December 23rd, 2013

Project Name: Munjoy Heights
Six new buildings comprising 29 residential townhouses; one existing house on reconfigured lot

Project ID: 2013-228

Project Address: 79 Walnut Street

DRAWING NO.
SN-1

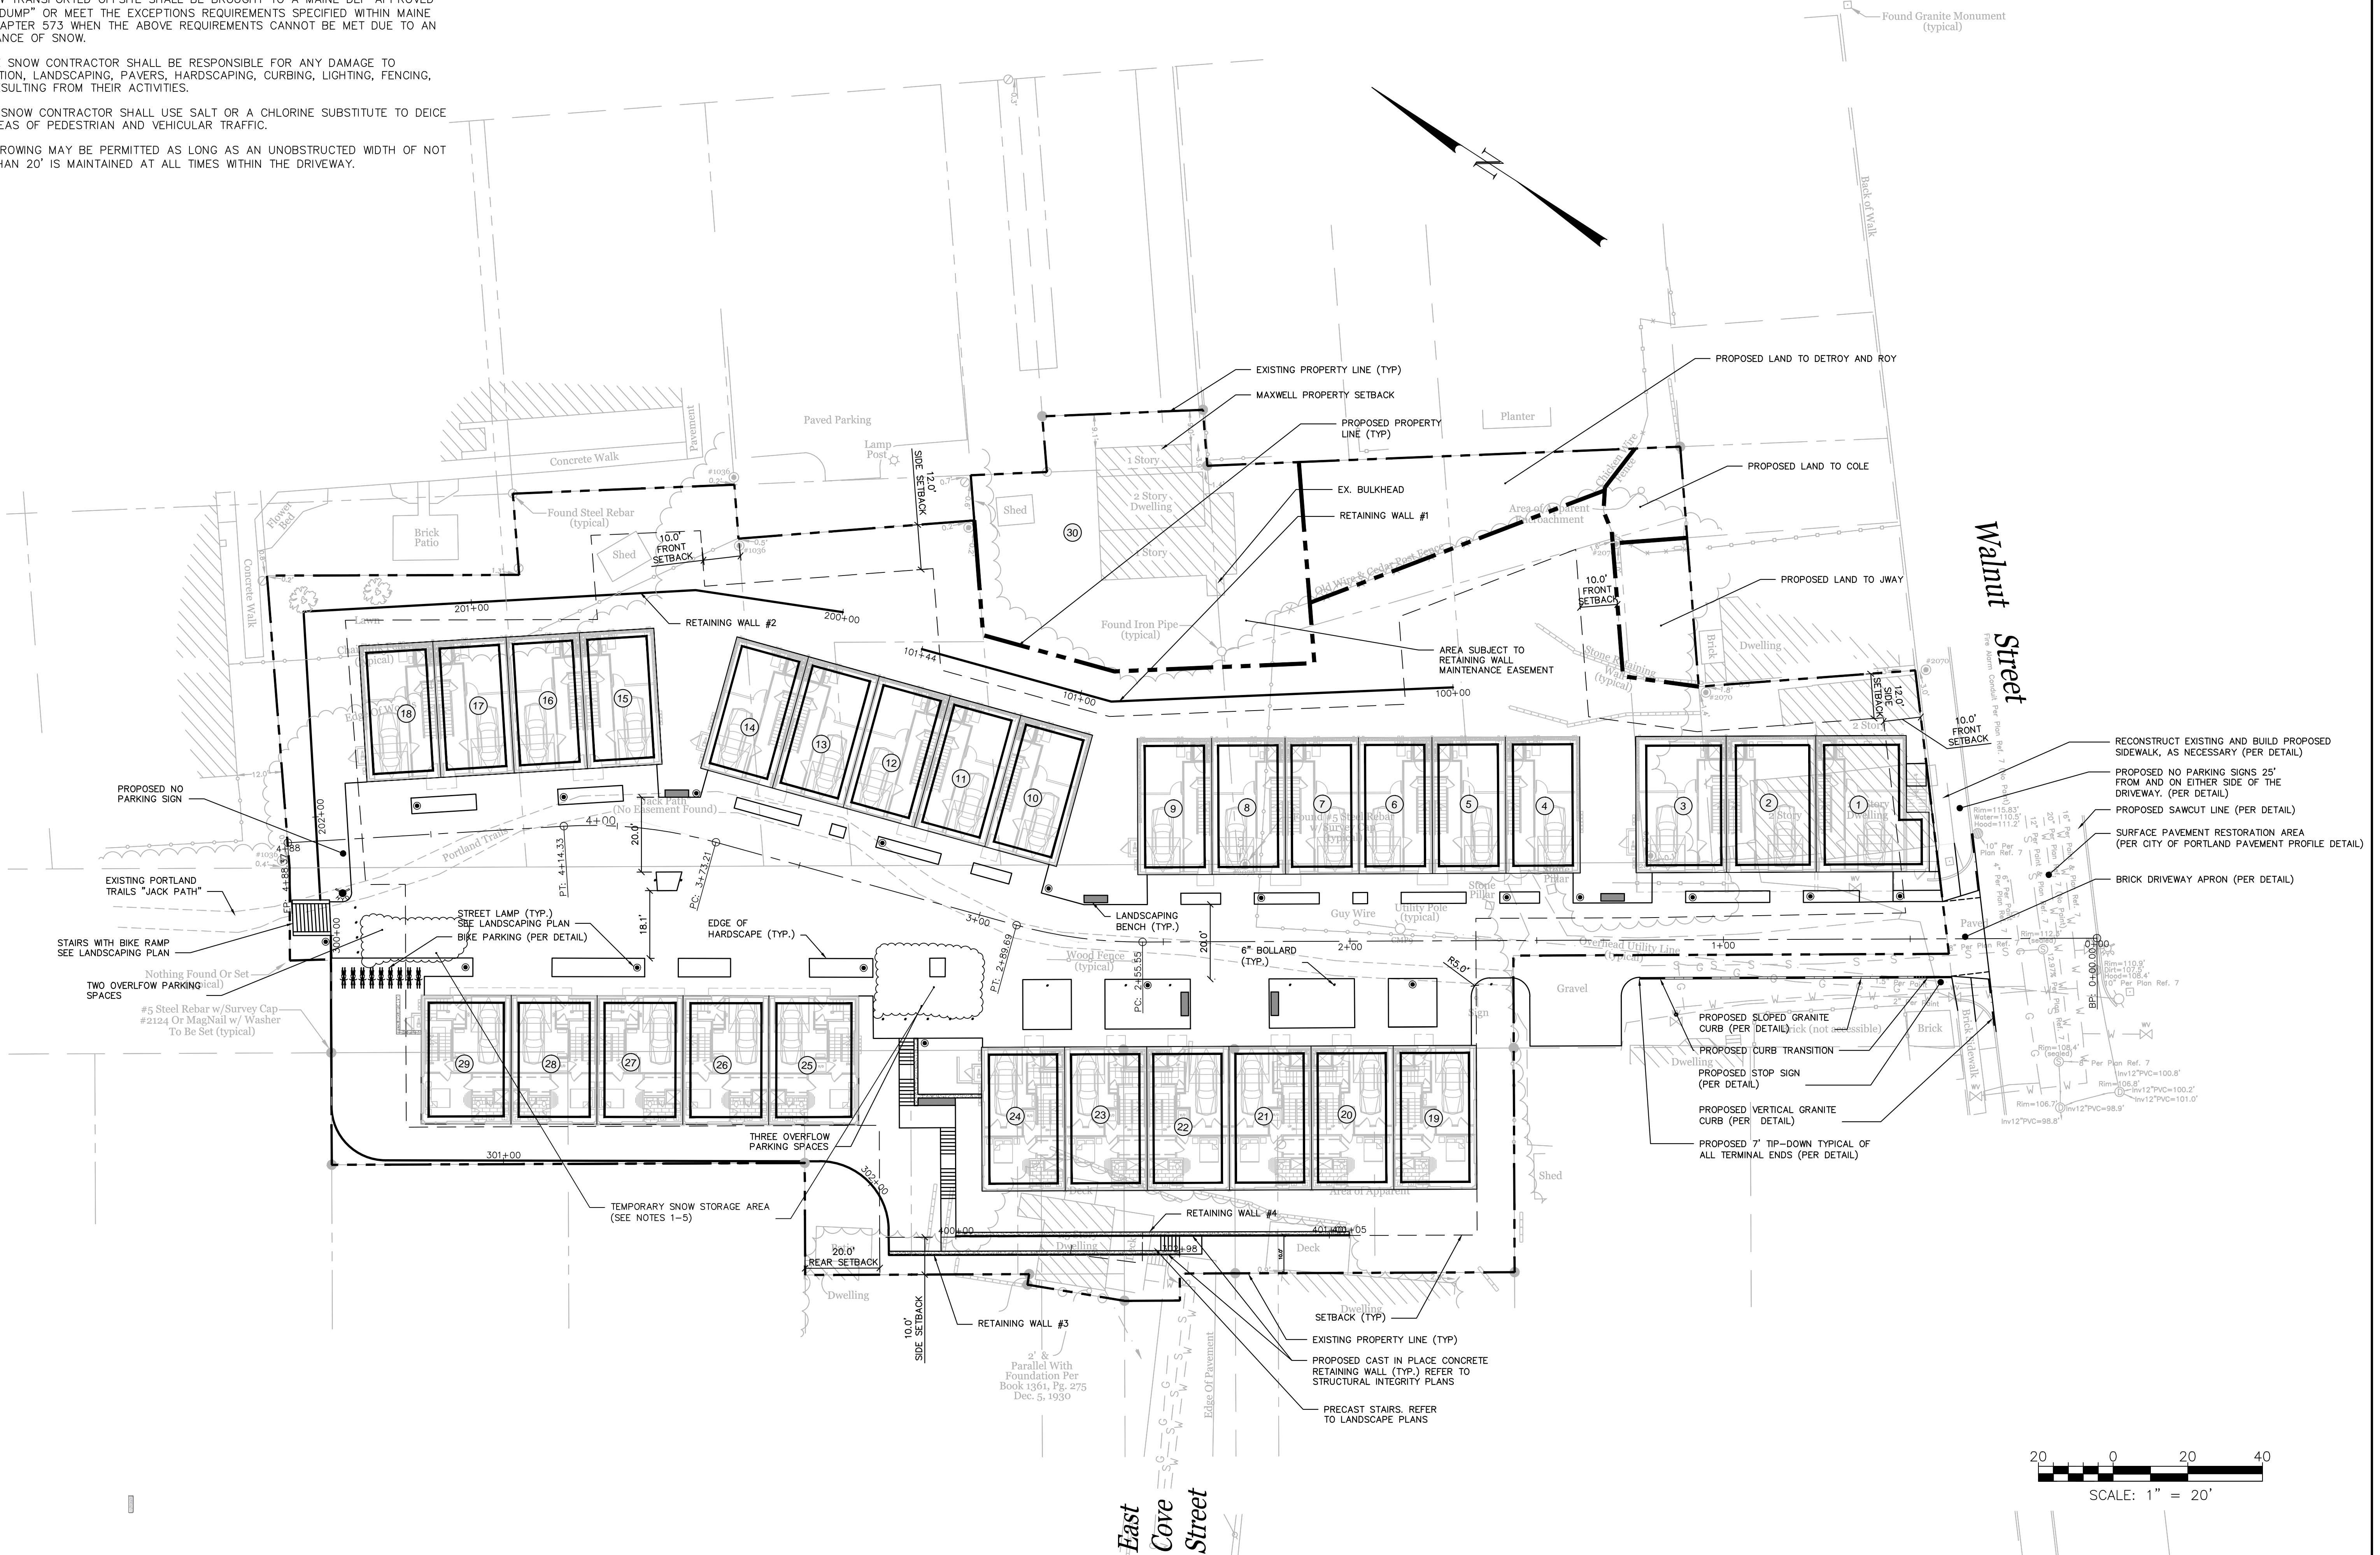
- That the minimum vehicle access of 20 feet is maintained at all times by adequate snow removal in accordance with the approved Snow Storage Plan (Plan 21 to this Report) and a specific prohibition on parking in front of the garages for Units 1-11 due to encroachment into the 20 foot circulation area required by the fire Department.
